CITY OF ALBUQUERQUE

August 7 2008

**Re: NMEFCU Coors/Lamonica Grading and Drainage Plan
Engineer Stamp 8-5-08 (P10/D4)**

Date:	No.	Revision:	Date:	Job No.
T2/23/13				2021
Drawn By: BJB				CG-101
Ckd By: FCA				SH. OF

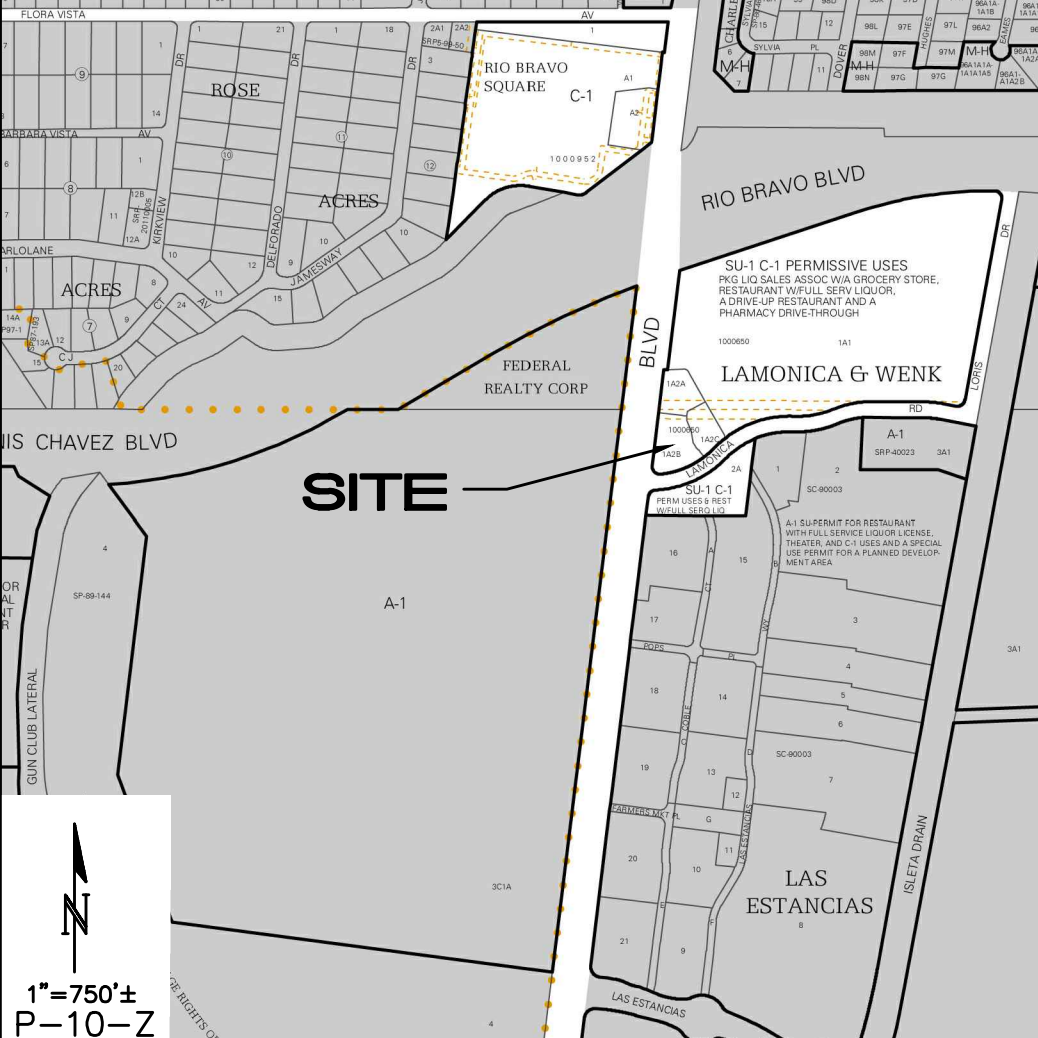
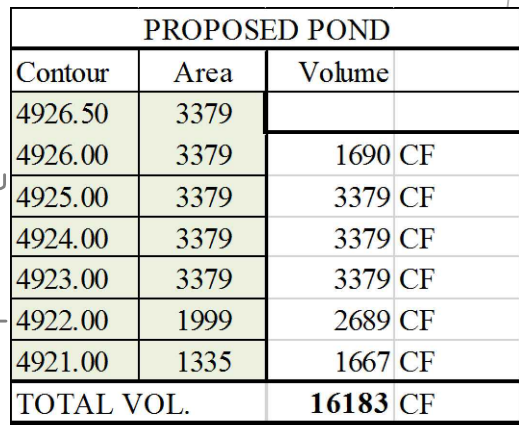
- Provide a water surface elevation for the ponds.
- Provide the 100 yr-10 day volume calculations in your data table.
- The berms should not drain onto the sidewalk.
- The text for Off-site Basin 3 is cut-off. Should this basin include a portion of Coors Blvd? Coors Blvd does not have curb and gutter at this location, so this lot most likely receives runoff due to the crown in Coors Blvd. Provide flow-line elevation data along Coors Blvd.
